Re: Certification Submittal for Permanent Certificate of Occupancy for
Holiday Inn Express
1921 Yale Blvd. SE
Architect's Stamp dated 11-02-09 (L-15/D029)

Re: Traffic Circulation Layout inspection
Holiday Inn Express and Suites
1921 Yale Blvd. SE
Albuquerque, New Mexico

**Re: Holiday Inn Express—Yale, 1920 Yale Blvd. SE,
Approval of Permanent Certificate of Occupancy, (L-15/D029)
Engineer's Stamp Date: 11-27-07
Certification Stamp Date: 7-28-09**

The Letter of Certification submitted on 08-17-09 is **not sufficient** for acceptance by this office for final Certificate of Occupancy (C.O.). The following items need to be addressed:

STORM DRAIN RELOCATION PLAN

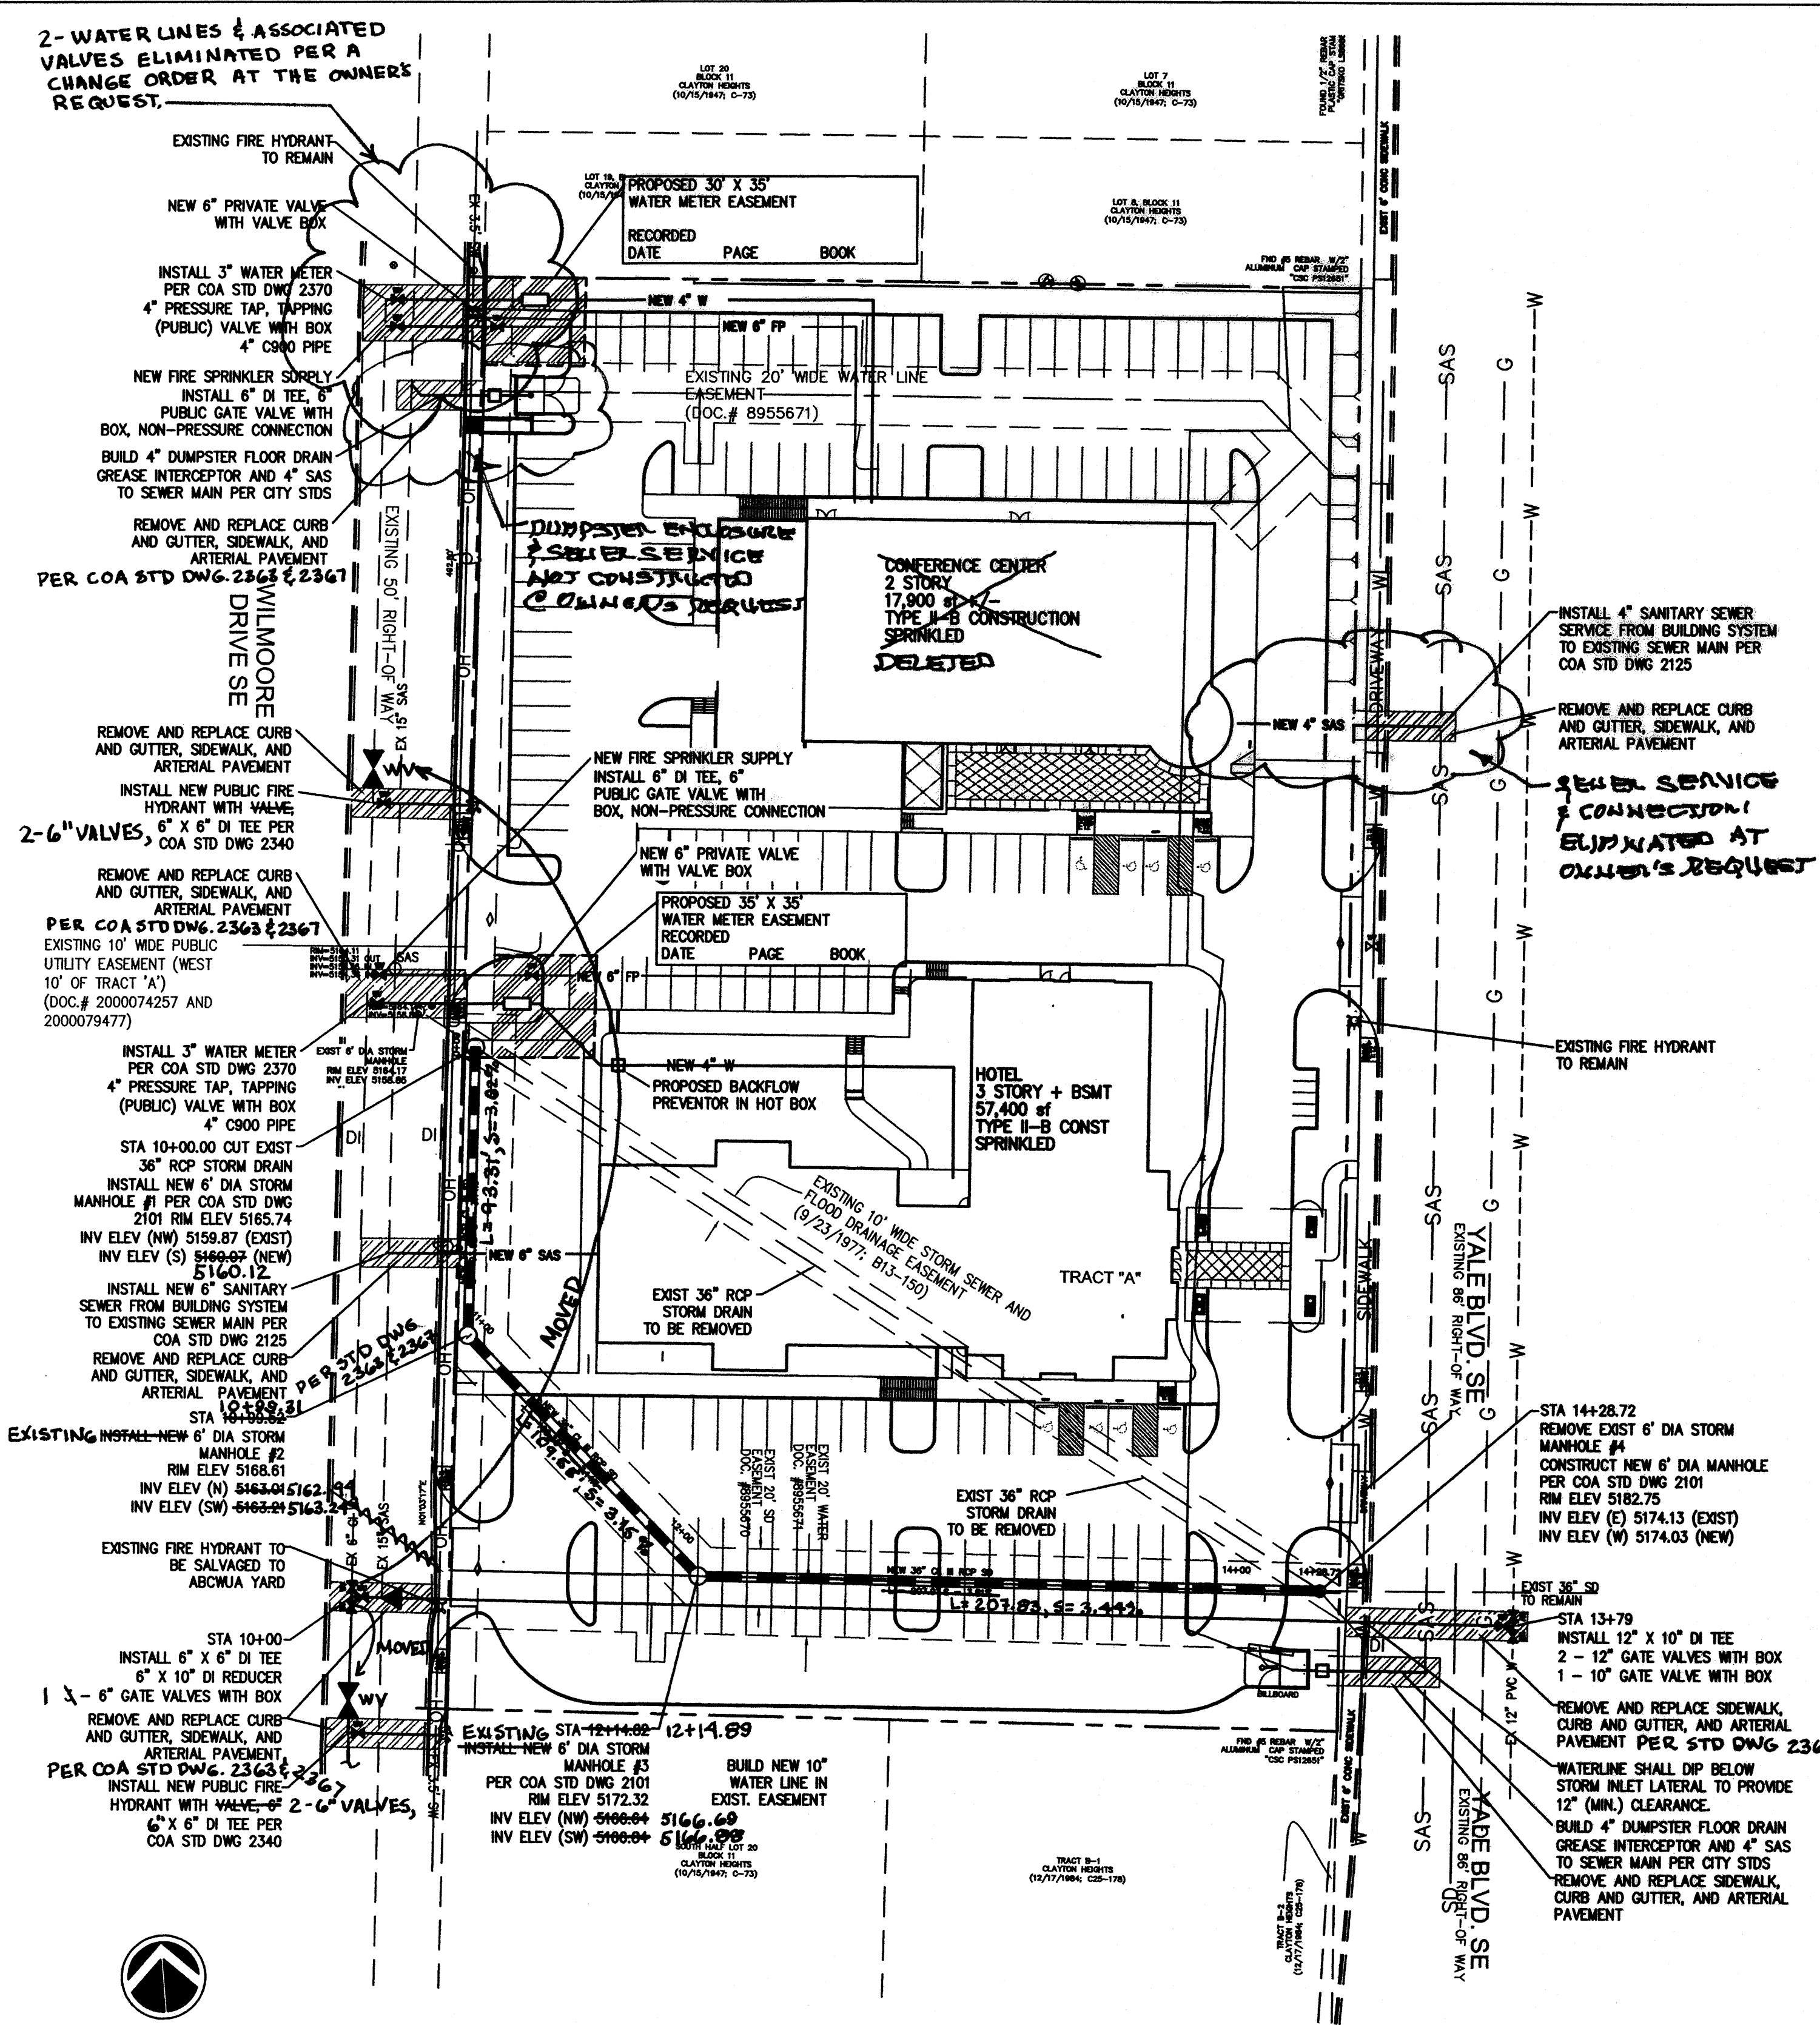
Prior to Permanent Certificate of Occupancy, attach a copy of the acceptance letter for the work order that relocated the storm drain and an Engineer's Certification per the DPM is required.

- Relocation of the existing storm drain must be performed under a separate work order approved through the DRC process. That work must first be financially guaranteed with an executed SIA before initiation of site work or approval for Building Permit.

This is to certify that the City of Albuquerque accepts the construction of the infrastructure provided in the Work Order Construction Plans, City Project No. 584683. The work was completed pursuant to the required infrastructure listed in the Subdivision Improvements Agreement (SIA) Procedure A, between 110 Sunport, Llc and the City of Albuquerque executed on April 18, 2008.

SITE PLAN for TRAFFIC CIRCULATION LAYOUT

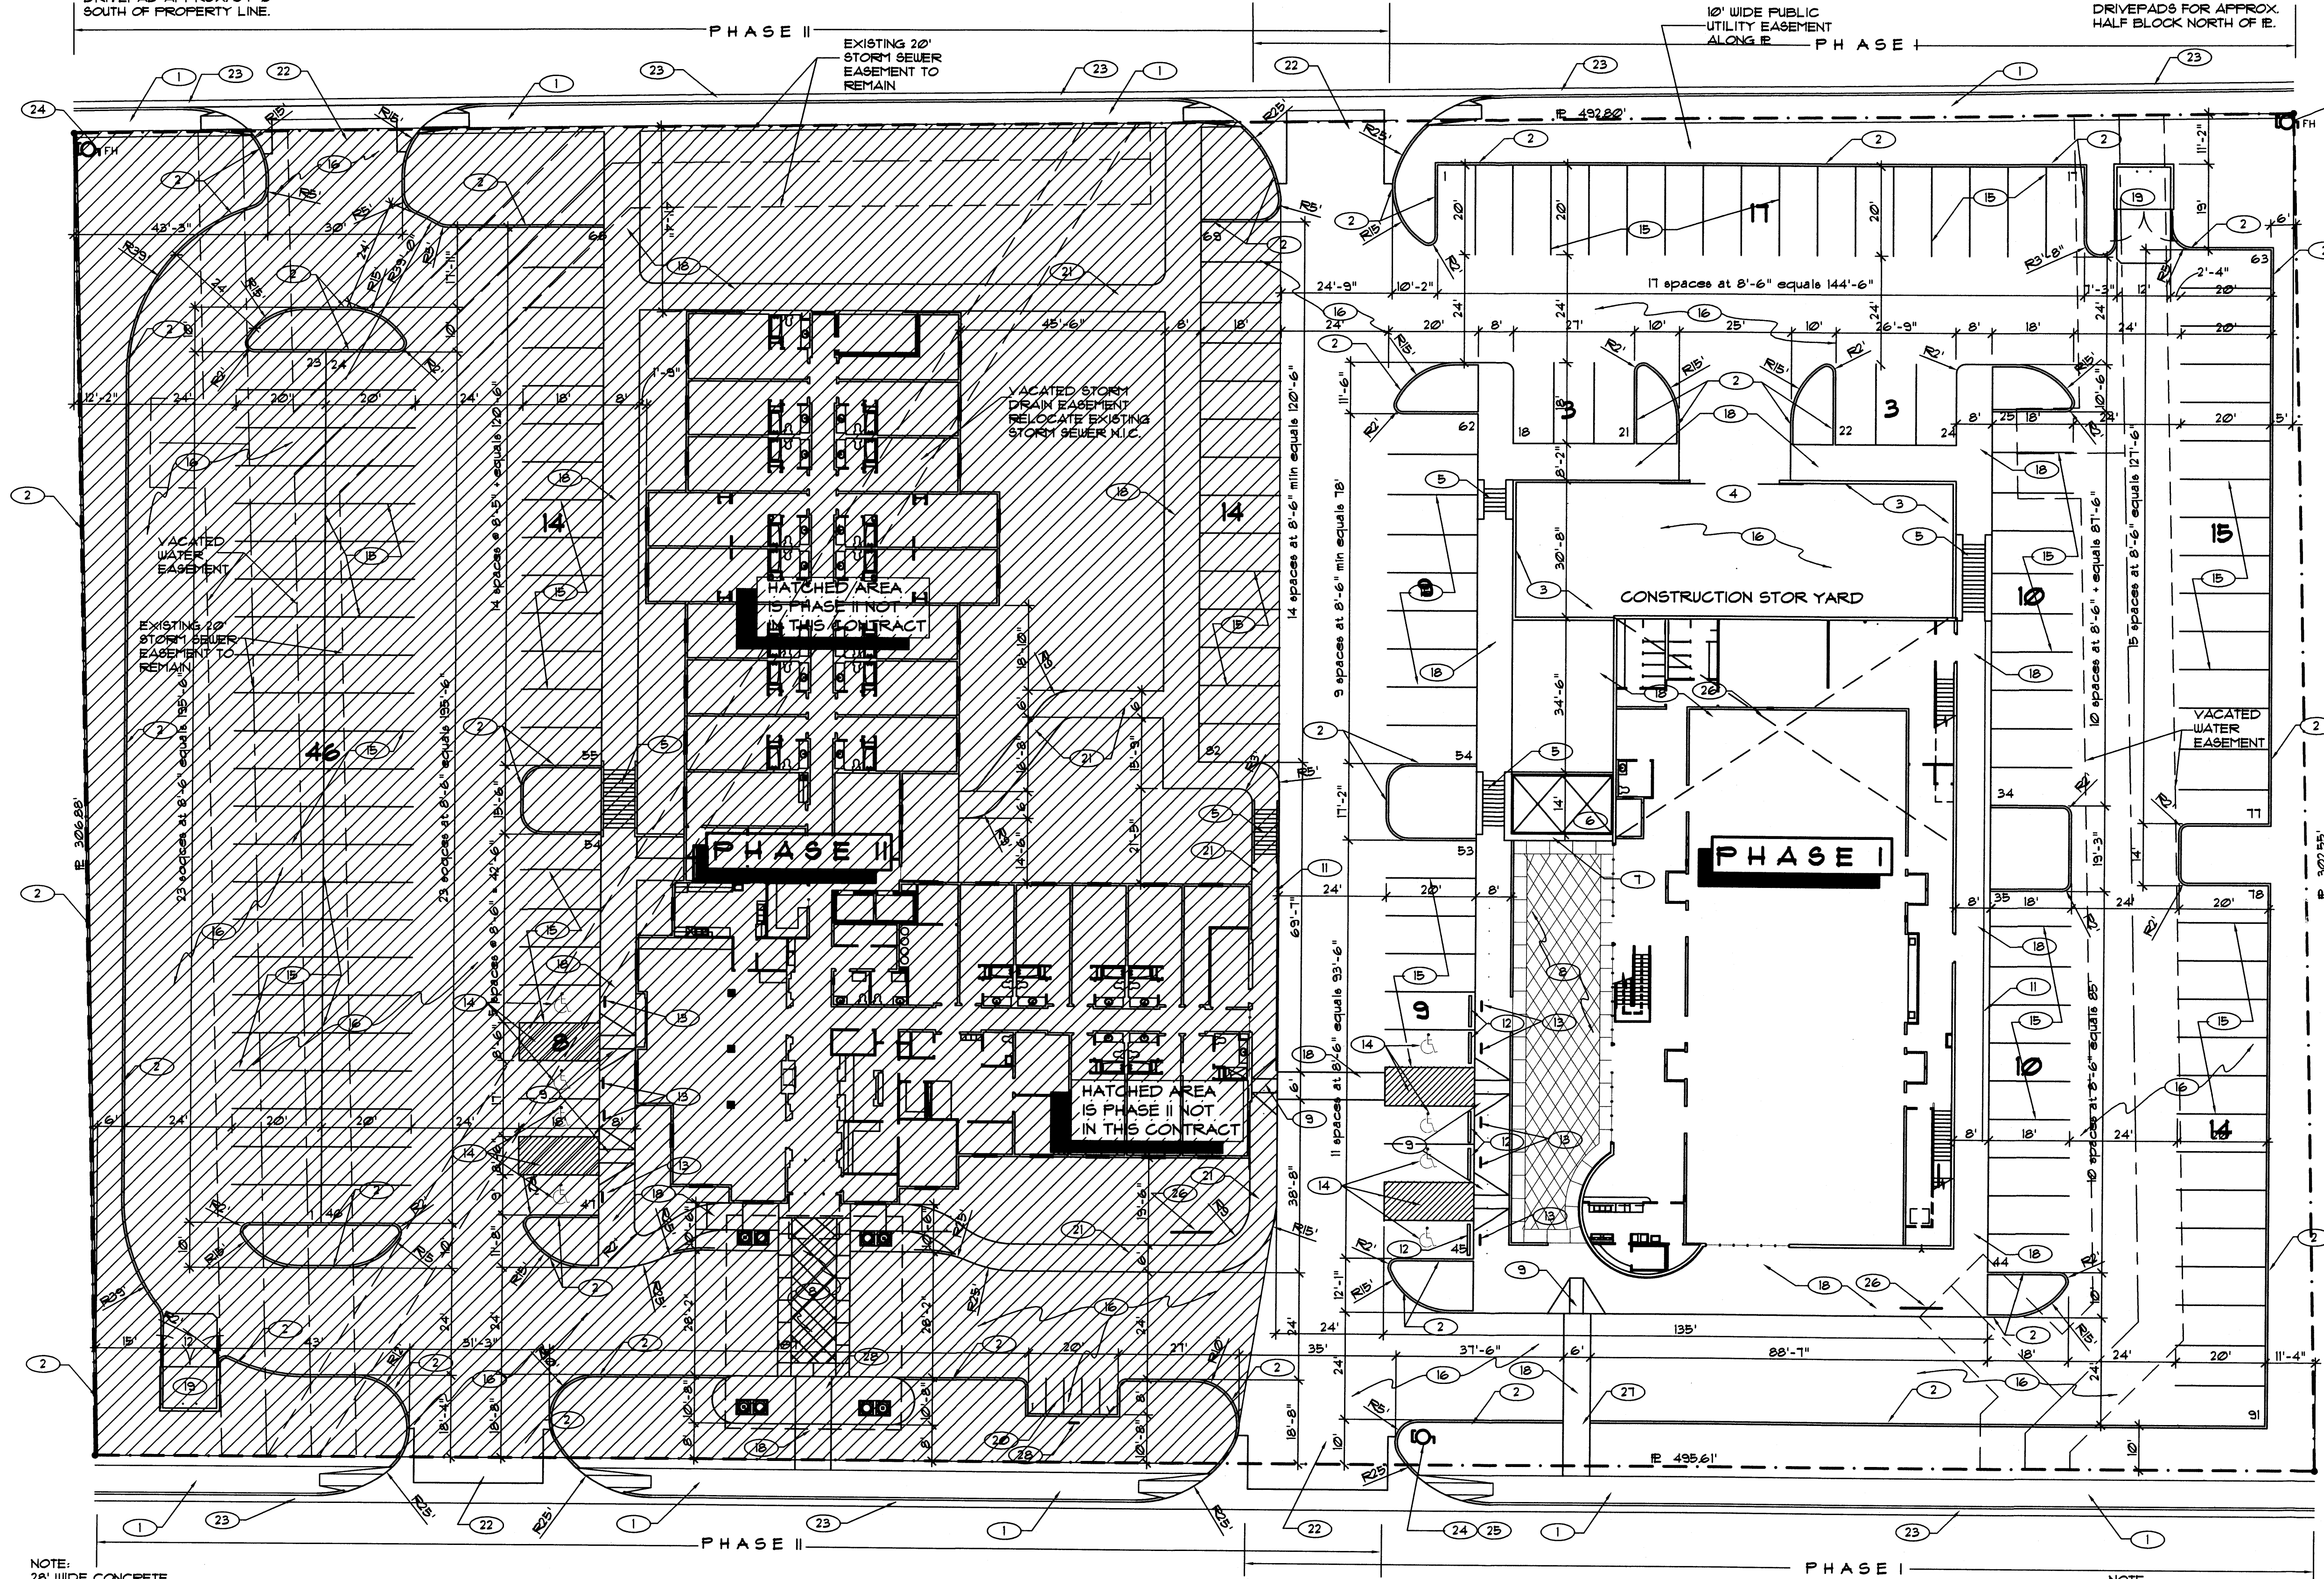
A Temporary C.O. has been issued allowing the outstanding **parking bumpers (provide on the stalls fronting the south side of building) and detectable warning surfaces (are required on all ramp landings with COA ROW)** issues to be completed within this time period. When these remaining issues have been fully completed, are in substantial compliance, and a final Certification for Transportation has been resubmitted to the City's Hydrology office for approval, a Permanent C.O. will be issued.

- Letter of Certification has the wrong project name (should be Holiday Inn Express instead of Staybridge Suites) and the wrong address (should be 1921 Yale Blvd. instead of 1350 Sunport) on letter.
- Since fence/wall was added to southern parking are you'll need to provide parking bumpers on stalls fronting the south side of the building (including stall adjacent to ADA parking).
- Detectable Warning Surfaces are required on all wheelchair ramp landings within City of Albuquerque property.

Parking bumpers have been provided on the stalls fronting the south side of building and detectable warning surfaces have been installed on all ramp landings with COA ROW as per your request letter dated 8/18/2009.
